Application by NNB Generation Company (SZC) Limited for an Order Granting Development Consent for The Sizewell C Project

The Examining Authority's third written questions and requests for information (ExQ3)

Issued on 09 September 2021

DRAWING TITLE:
MAIN DEVELOPMENT SITE
KEY PLAN
RULE 17 REQUEST FOR FURTHER INFORMATION

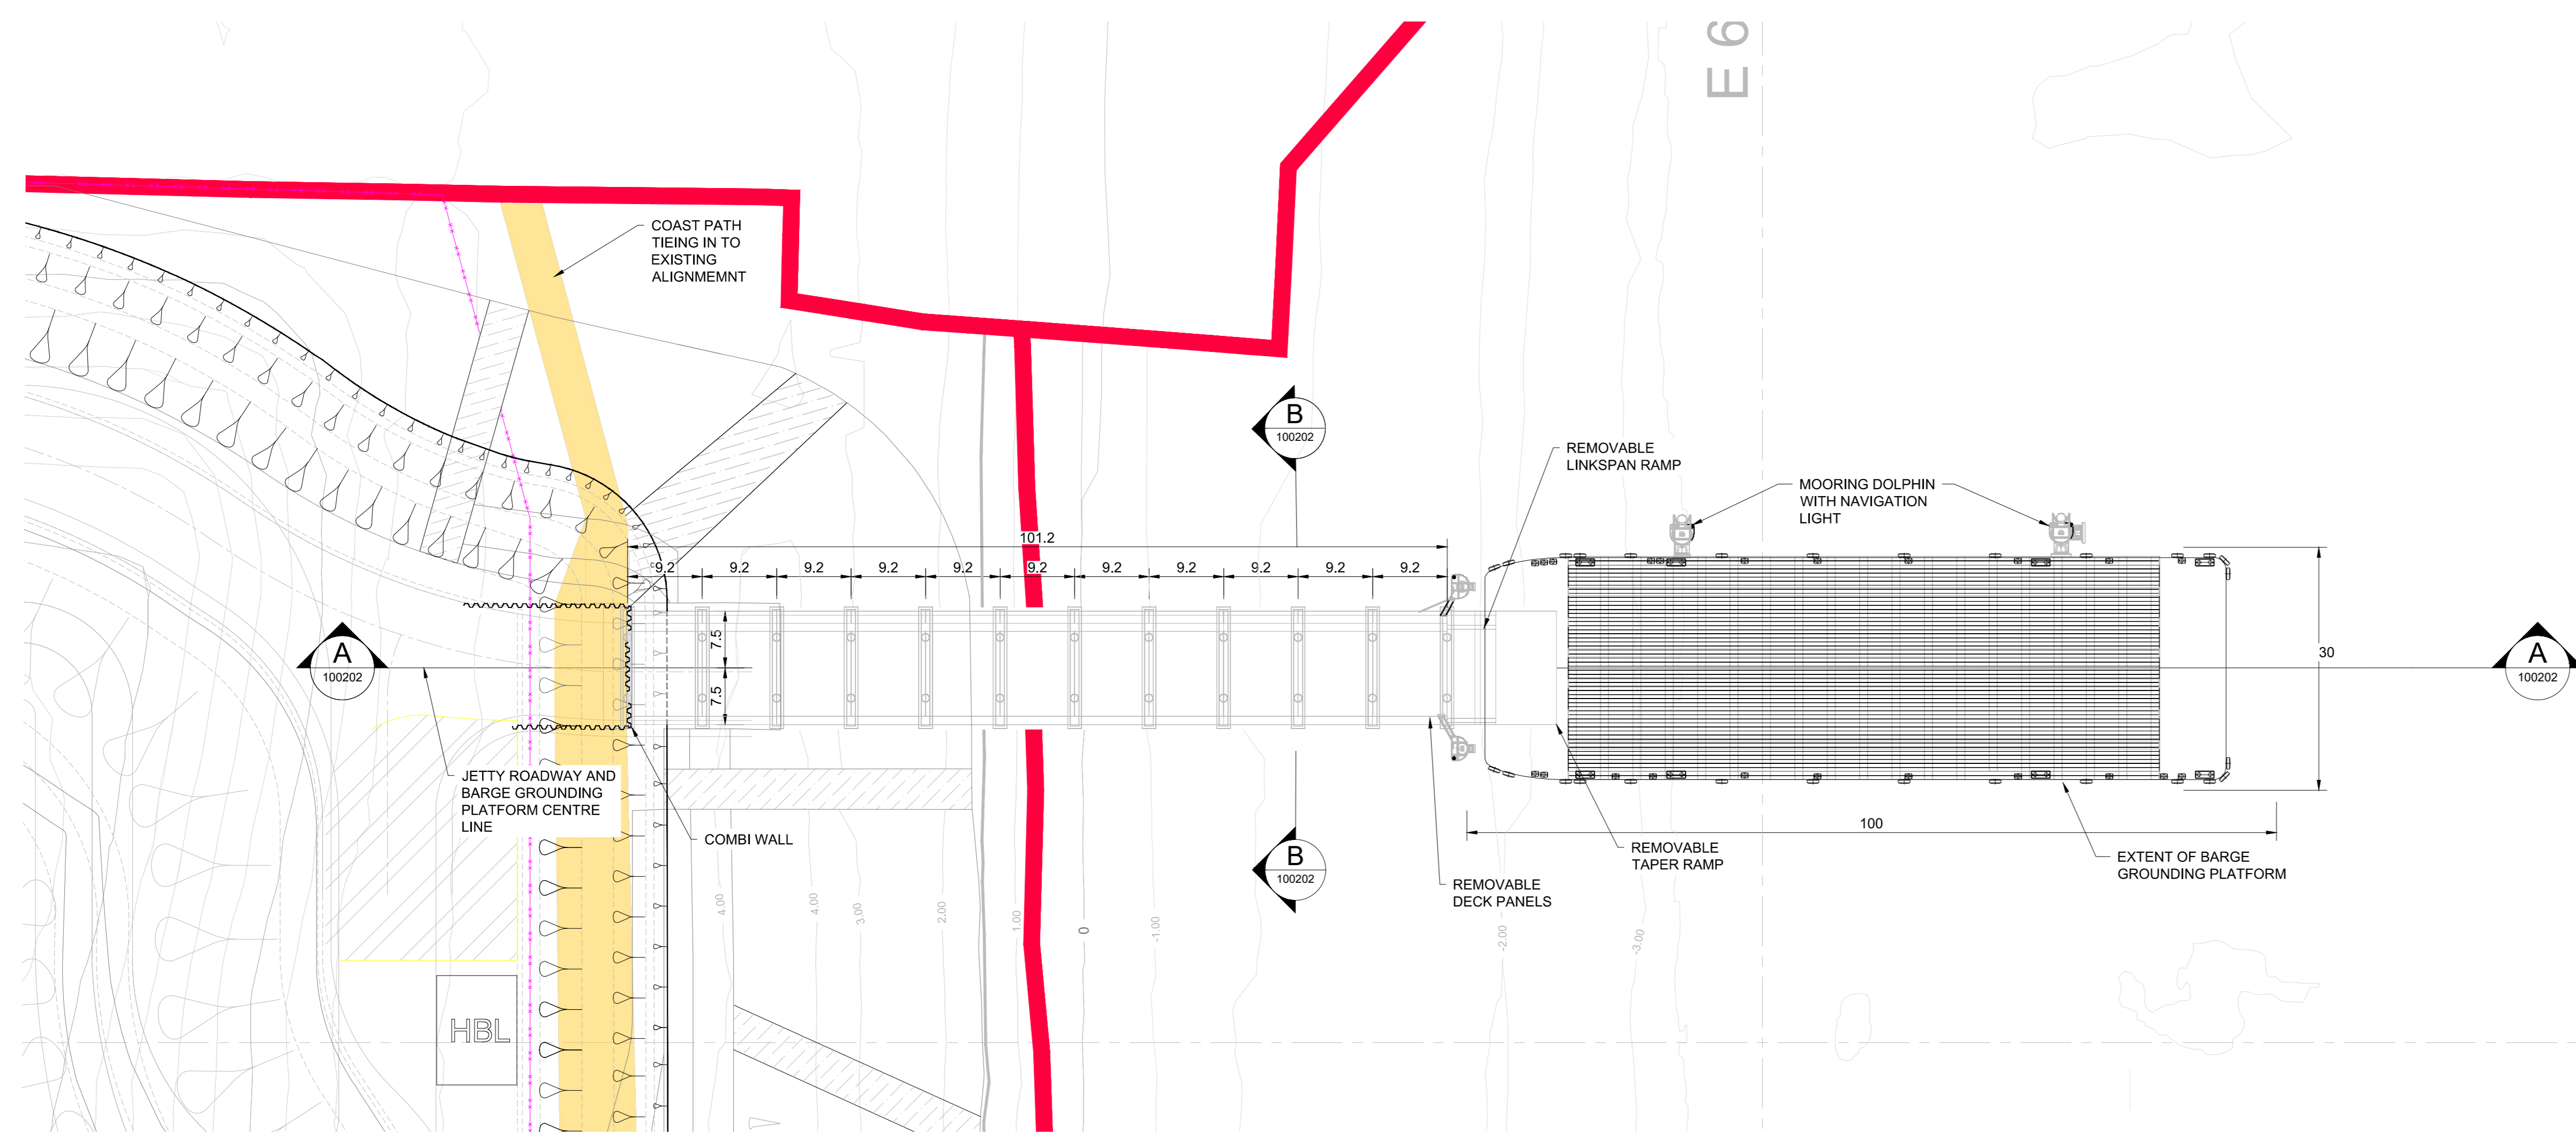
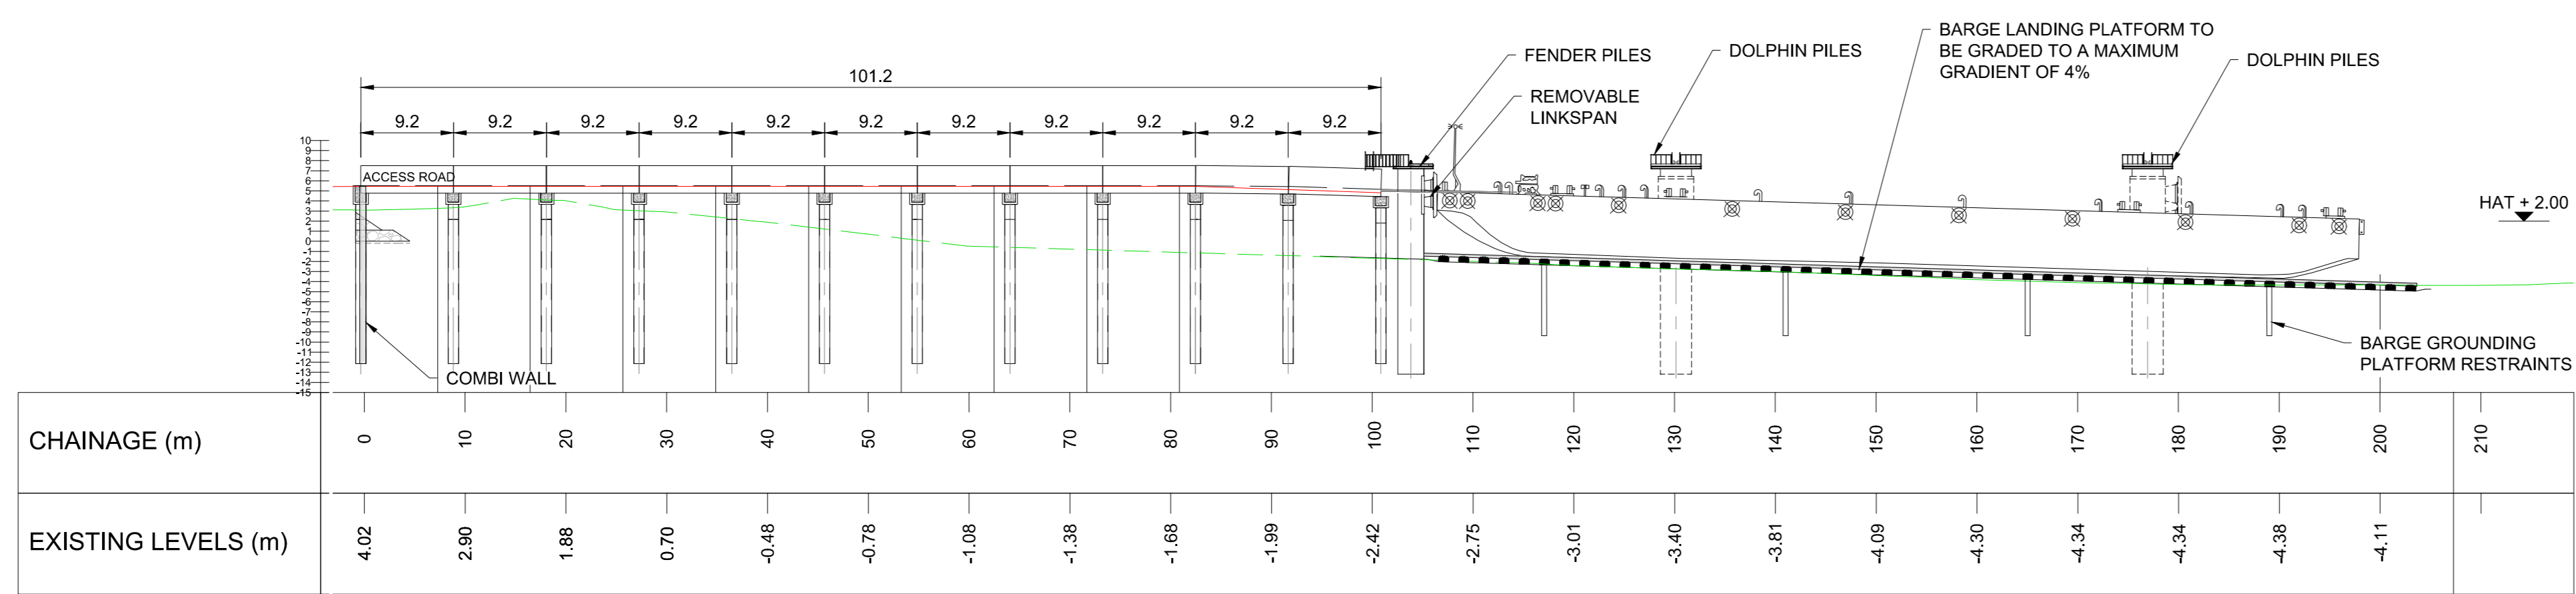
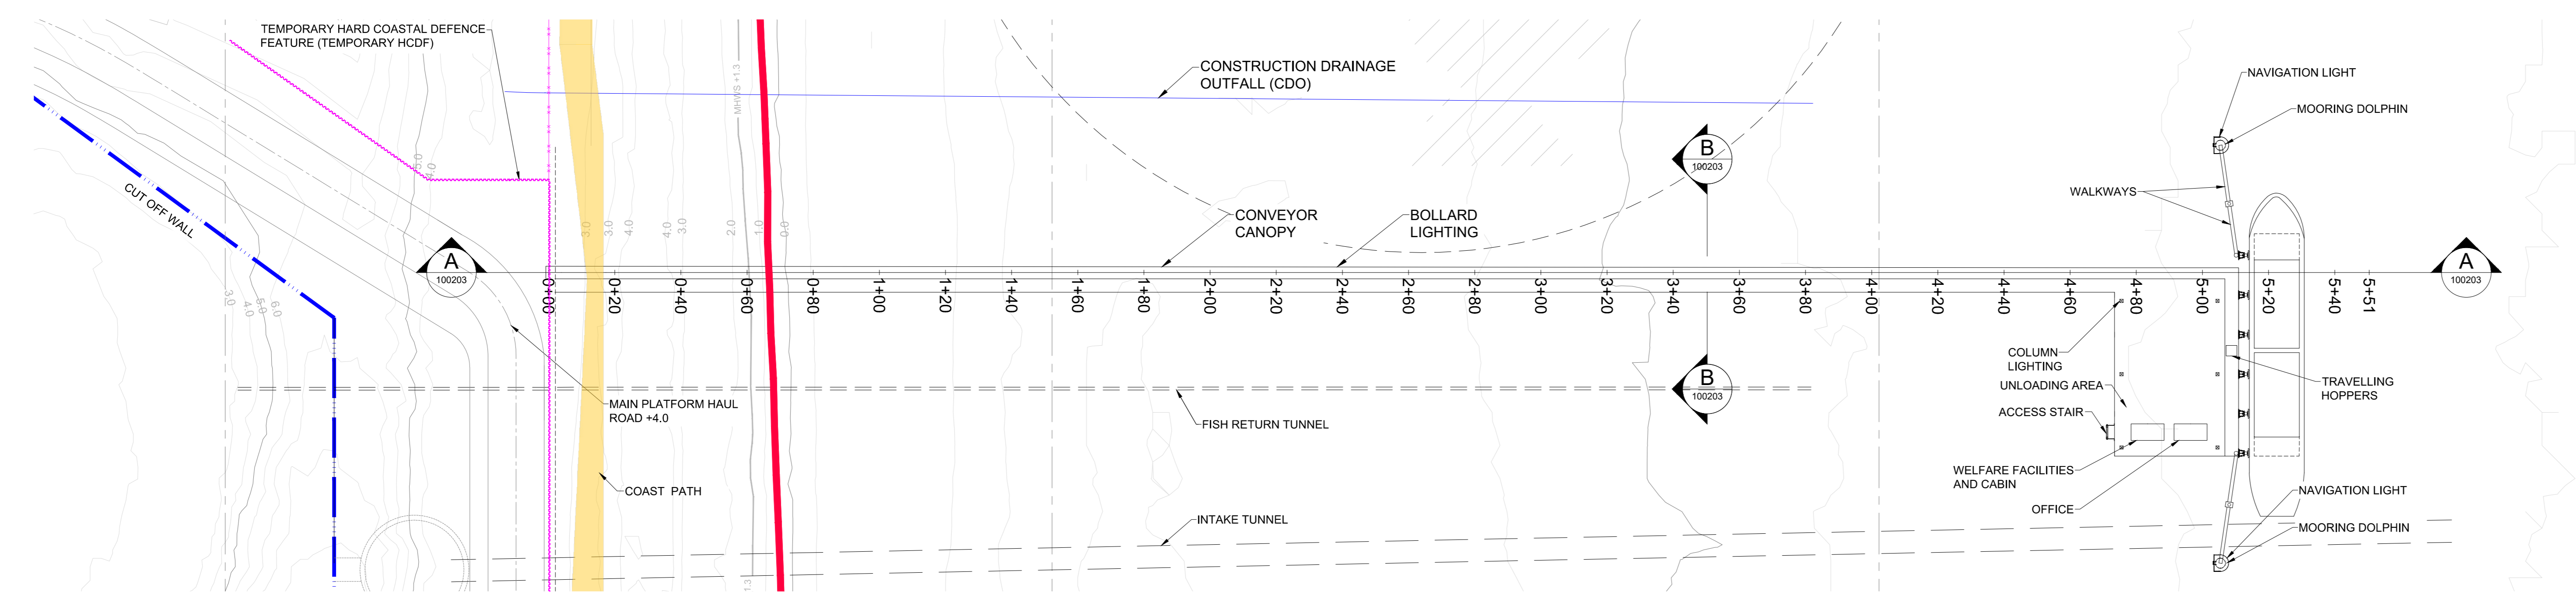
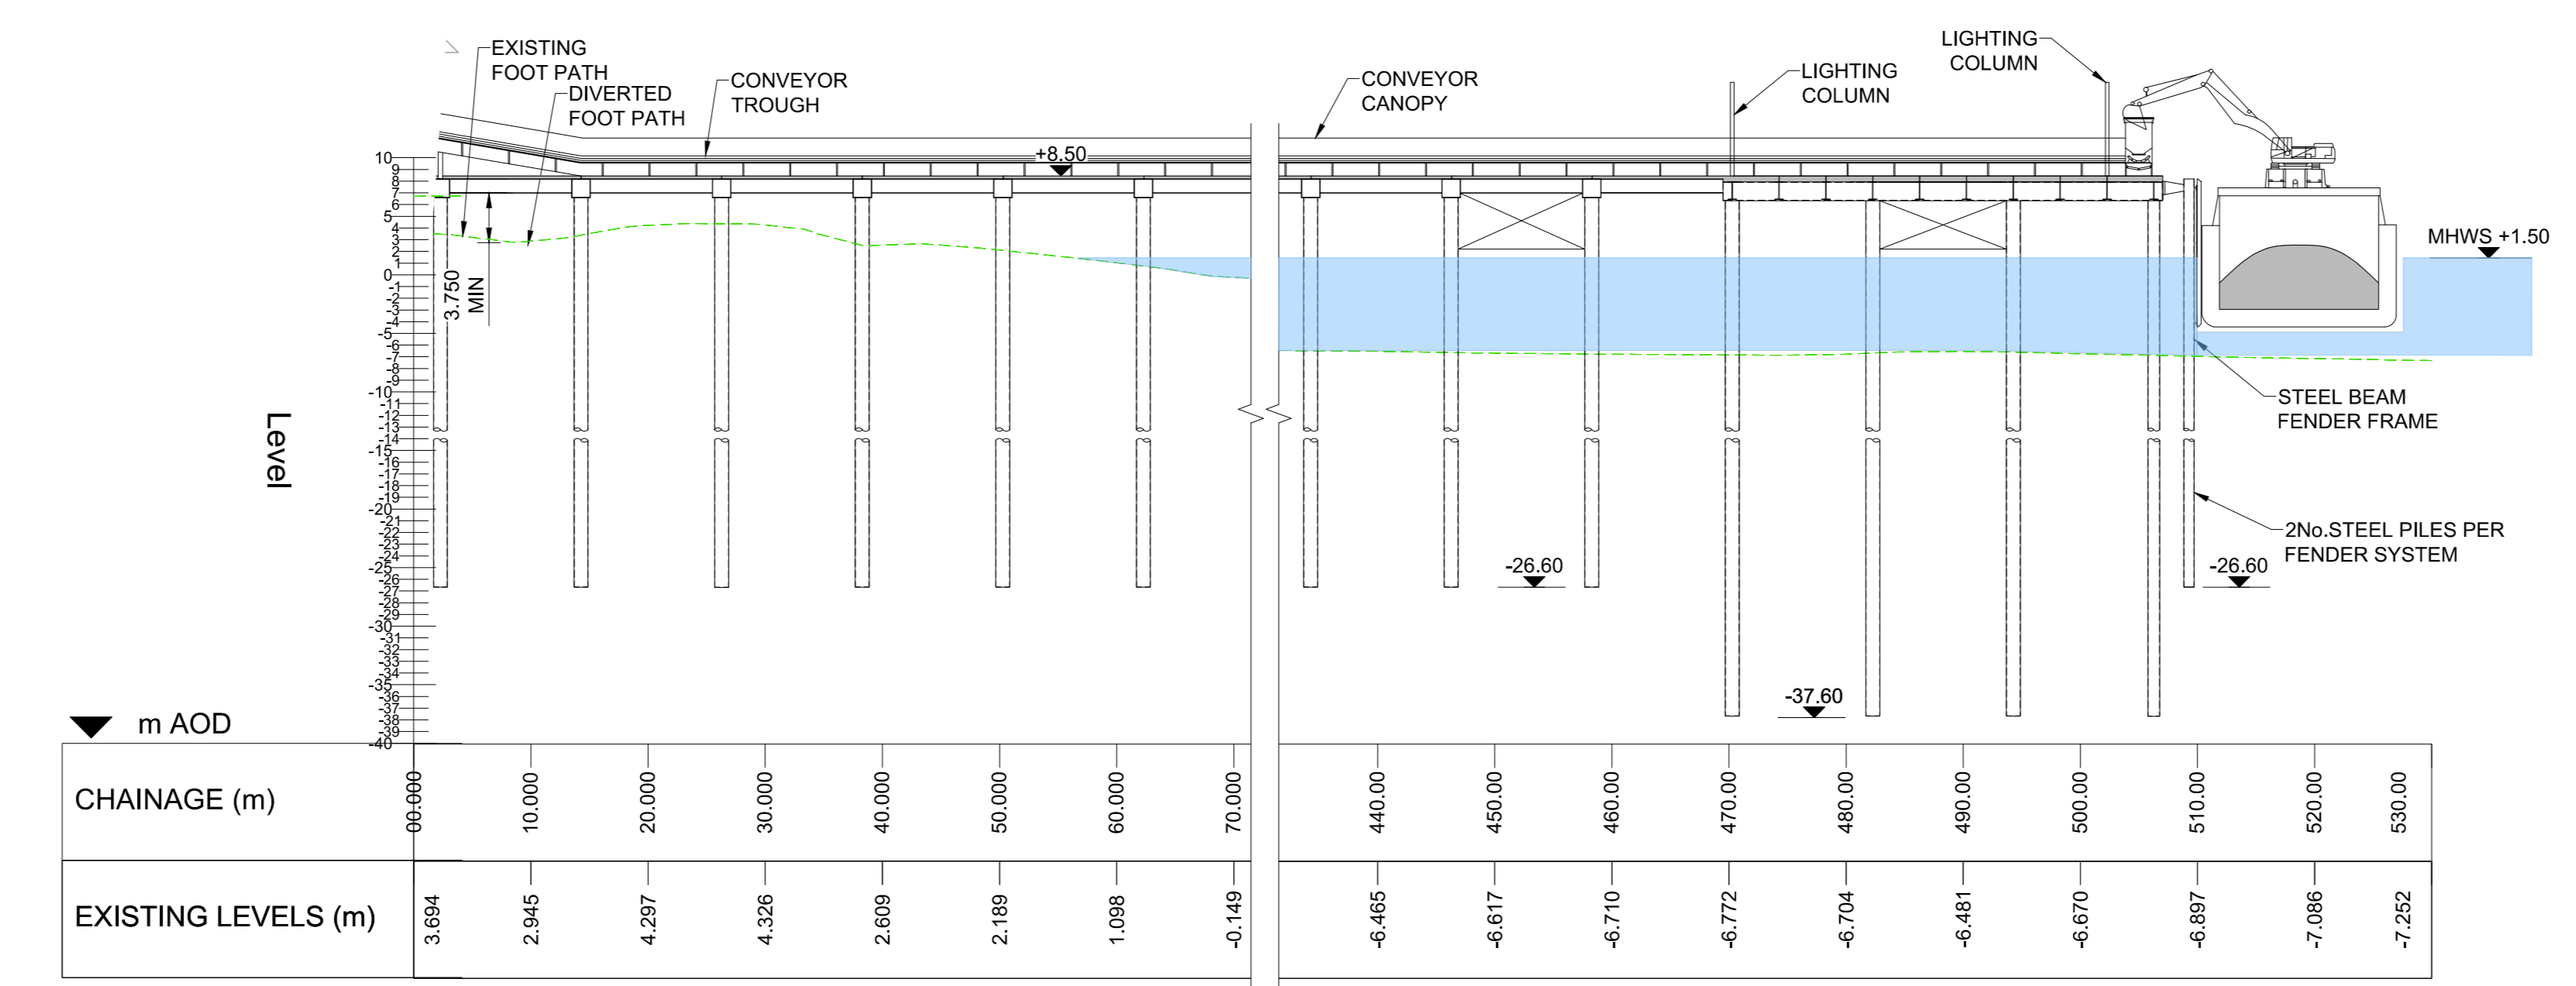
CG.3.10	The Applicant	<p>Impacts on coastal processes:</p> <p>The Deadline 5 submission of Bill Parker [REP5-191], states that the Applicant has yet to define its methodology for 'ground improvement' that will be a critical element in determining the resilience of the development in the long-term. Please indicate whether this methodology and details of ground improvement works been determined. If so, when will this information be submitted to the Examination? If not, how can a determination of future resilience be made in the absence of that information?</p>
CG.3.11	The Applicant	<p>Impacts on coastal processes:</p> <p>The Deadline 5 submission of Bill Parker [REP5-191], seeks details as to how the HCDF would be integrated with the SSSI crossing, the BLF and jetty. The Applicant has</p>

ExQ3	Question to:	Question:
		submitted drawings at Deadline 7 relating to the permanent and temporary BLFs and SSSI crossing. Please explain in detail including by reference to any submitted plans how that would be achieved?
CG.3.12	The Applicant	Impacts on coastal processes: The Deadline 5 submission of Bill Parker [REP5-191], states that there needs to be a recognition that Sizewell Bay is a complex and dynamic environment. (i) Please explain how the assessment of long-term impacts have taken account of integrated system elements of the design and the potential for "emergent behaviour" from the natural environment? (ii) Should an independent expert assessment of the system elements operating in combination be carried out? (iii) If not, why is this not considered to be necessary?
CG.3.13	The Applicant	Impacts on coastal processes: The Deadline 7 submission of Nick Scarr highlights the fact that the adjoining Sizewell B has a 10m AOD sea defence crest height and the new proposed sea defence for Sizewell C (14.6-16.4m AOD) does not appear to cover the frontage of Sizewell B. Whilst paragraph 3.2.21 in the Applicant's 'Sustainability Statement [APP-617] is noted, please explain the apparent discrepancy and how any potential risk posed by the Sizewell B defences to either site in the long-term would be overcome and secured by the draft DCO?
